Subject: Re:RE: Proposed Development 44a Ocean Drive, BN125QP

ref no: **FG/17/22/HH (previously FG/199/21/PDH)**

I wish to make you aware of my objection to the proposed development at 44a Ocean Drive.

Proposed Ground Floor Plan

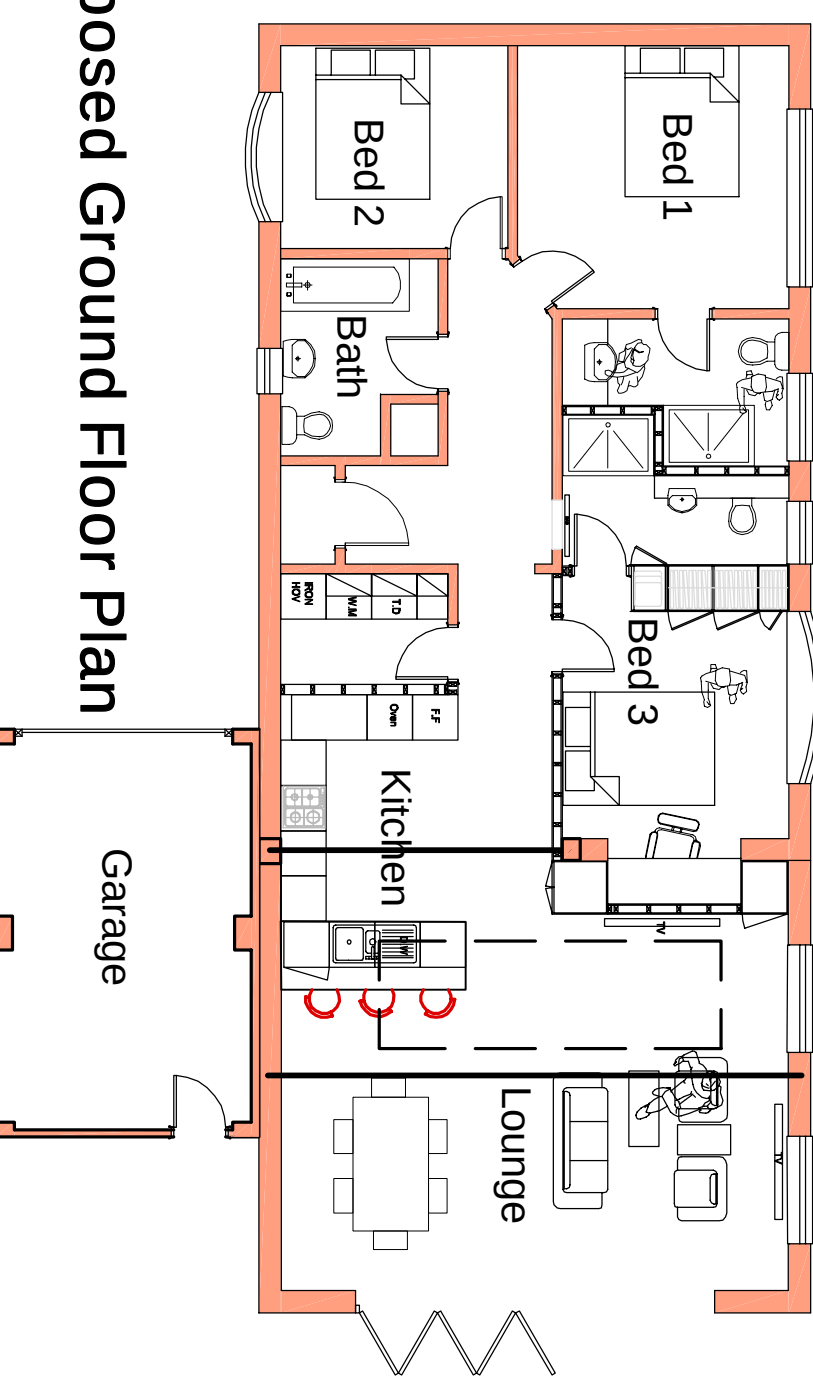
The extension is larger than initially indicated by my neighbour and comes across the entire width of the side of his property to the garage wall and extends past the garage wall. This means that the current side entrance which has a step up into his garage, will now be an integral door and the plans indicate a further door will be attached to the rear of the garage, presumably with a step up to enter the garage, and this entrance will be very close to my fence.

On my side of the fence is my patio which currently is a private area. The proposed new door will have an impact in that it will not afford adequate privacy for me and my property, particularly with the right to enjoy the privacy and the quiet enjoyment of my garden due to the use of this new entrance to the garage.
